**Notice of EIS for Cockle Bay Park - 241-249 Wheat Road, Sydney (SSD-9978934)**

Thank you for your referral dated 4 November 2021 inviting comments from the Heritage Council of NSW on the above State Significant Development (SSD) proposal.

As delegate of the Heritage Council of NSW, I provide the following comments:

- 01**
Existing escalators and stairs at Pymont Bridge
- 02**
New lift for access to Pymont Bridge level and Northern Park / Civic Link
- 03**
Northern Podium Circulation Node
- 04**
Central Podium Circulation Node
- 05**
Southern Podium Circulation Node
- 06**
New Druiitt Bridge interface

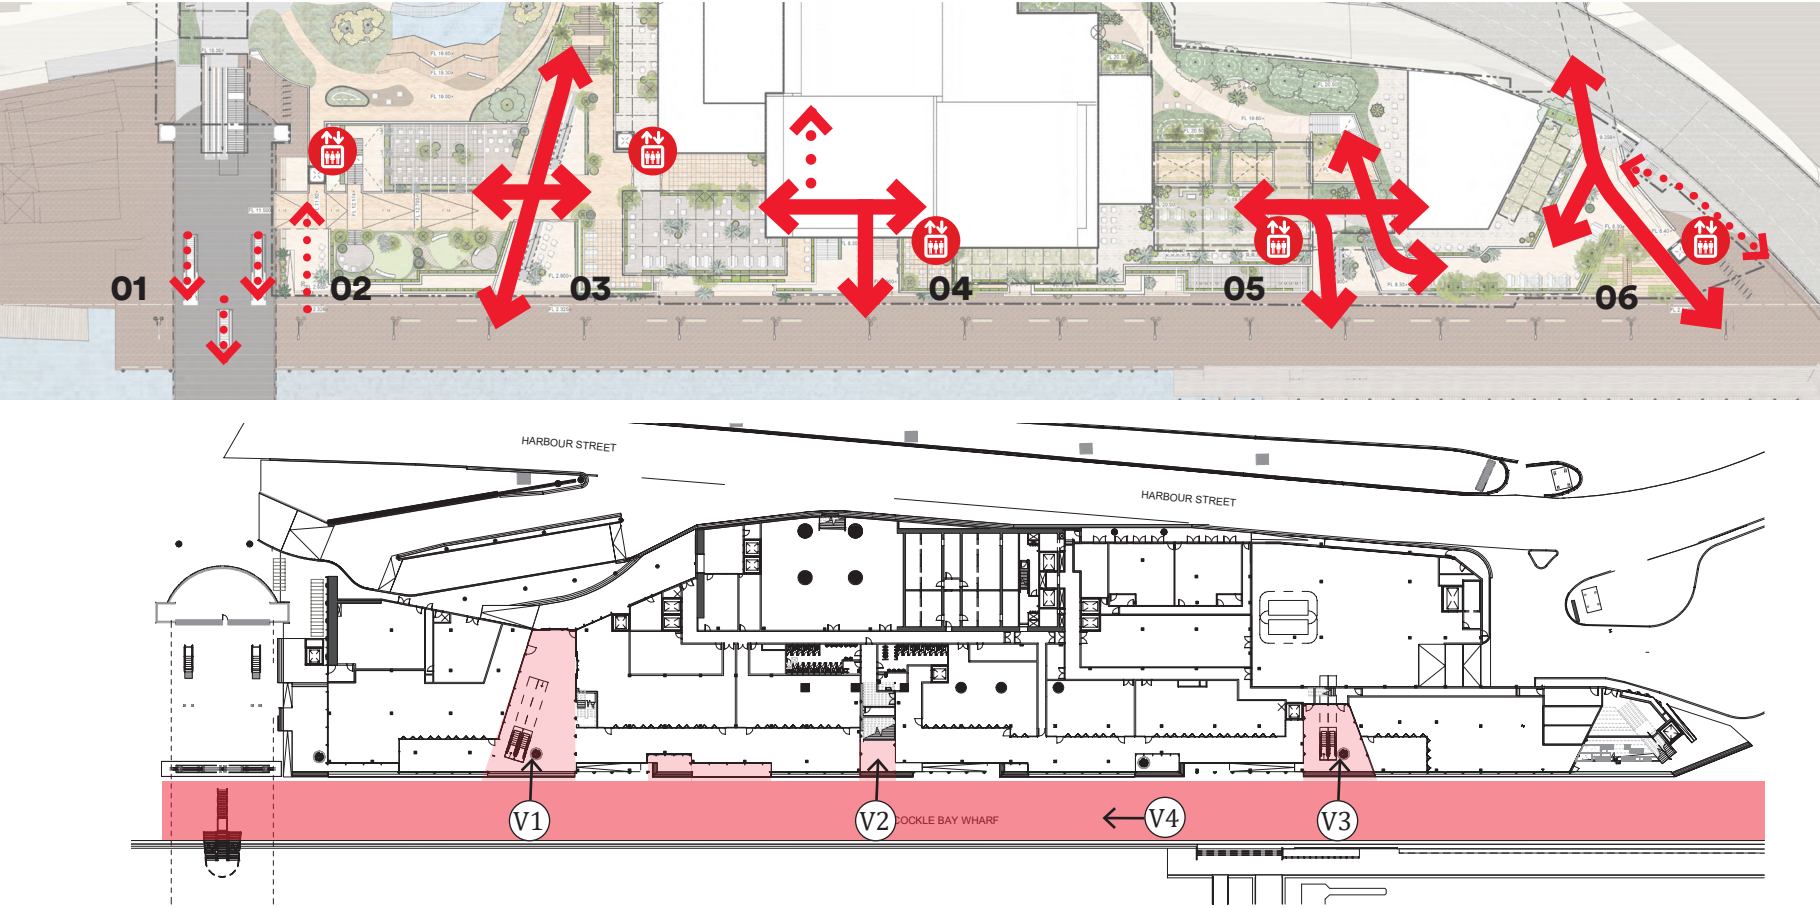
- The new escalator and stair additions to the eastern end of the bridge would have an adverse impact on the state heritage register listed values of the bridge including its historic and aesthetic values. Options to relocate the additions further back from the significant bridge stone piers should be explored to achieve a more sympathetic interface that minimises impact. It is considered that the adverse visual impacts resulting from the approved podium location and alignment in close proximity to the bridge structure would be further increased by such additions.

- The new lift structure in the immediate vicinity of the bridge would have an adverse visual impact and the addition should be reconsidered in terms of its location, form and scale.

5. Options to relocate the proposed escalators and stairs further back from the significant stone piers of Pyrmont Bridge should be explored to achieve a more sympathetic interface with the bridge structure, which minimises visual and physical impact. New additions are to be carefully located and interference (visual and physical) with historic fabric avoided in order to maintain the simplicity and elegance of the original design of the bridge in its harbour setting.

6. The proposed new lift structure in the immediate vicinity of the bridge should be reconsidered in terms of its location, form and scale to minimise visual clutter at the eastern end of the Pyrmont Bridge.
